**Consultation Response from Mike Hibbert,
KC Waste Strategy(Refuse & Recycling)**

2023/93803 1st floor, The Packhorse Centre, 19-31 King Street, Huddersfield, HD1 2RT

Change of use of 1st floor restaurant to form 10 apartments including external elevation alterations on the King Street frontage and 10 roof lights at 19-31 King Street

Responding Ref: WPS 23-076

Proposed 1<sup>st</sup> Floor Plan

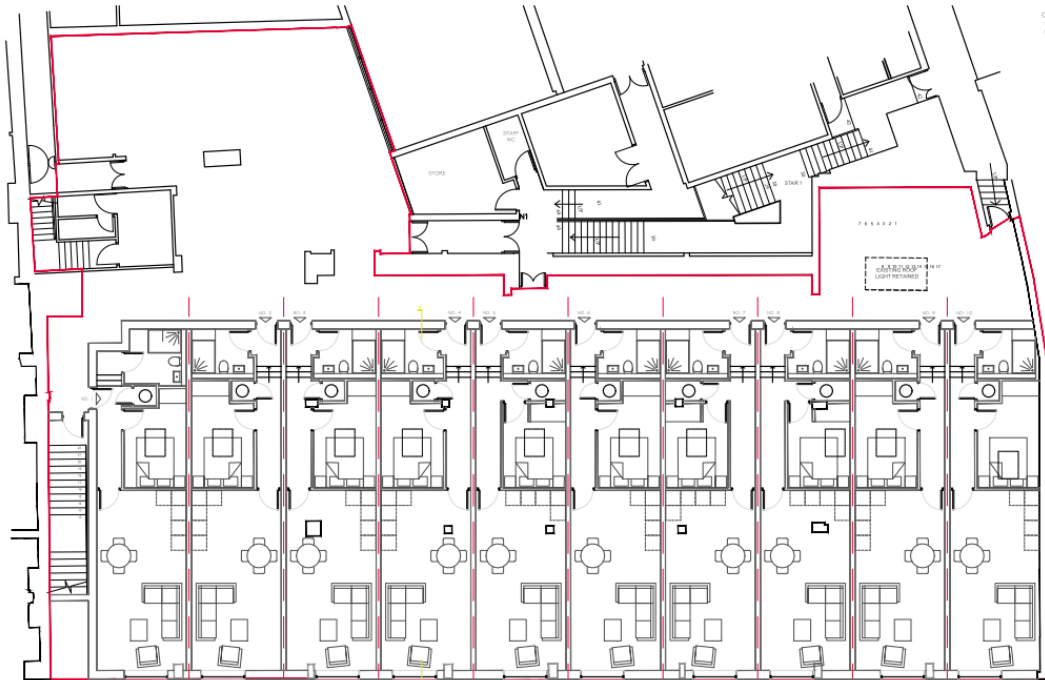
The application includes a Plan (PL)-(04) Rev A dated 9/1/2024 but there is no indication of waste storage shown. The section on the application form relating to waste states "Basement of the Packhorse Centre - collected via a private management agreement which has been set up between the Pack Horse Centre and Veolia."

- For 10 apartments the recommended waste storage provision is between 1000ltrs and 1800 ltrs (10X180 litres) for both residual and recycling bins. Separate 240 ltrs bins for individual apartments would not be practical due to limited space. Appropriate waste storage provision would be 2 x 1100 ltrs wheeliebins.
- The waste store should be secure to prevent theft, unauthorised use/ fly tipping or rough sleeping.
- Additional information is required detailing if waste will be collected by a concierge service or if residents will deliver waste direct to wheeliebins in the waste storage area. The walk distance for residents should be less than 30m as specified in guidance.

- The waste storage area should have suitable lighting and be designed so it can be cleaned. Further details are sought on surfacing and security of the bin store area.
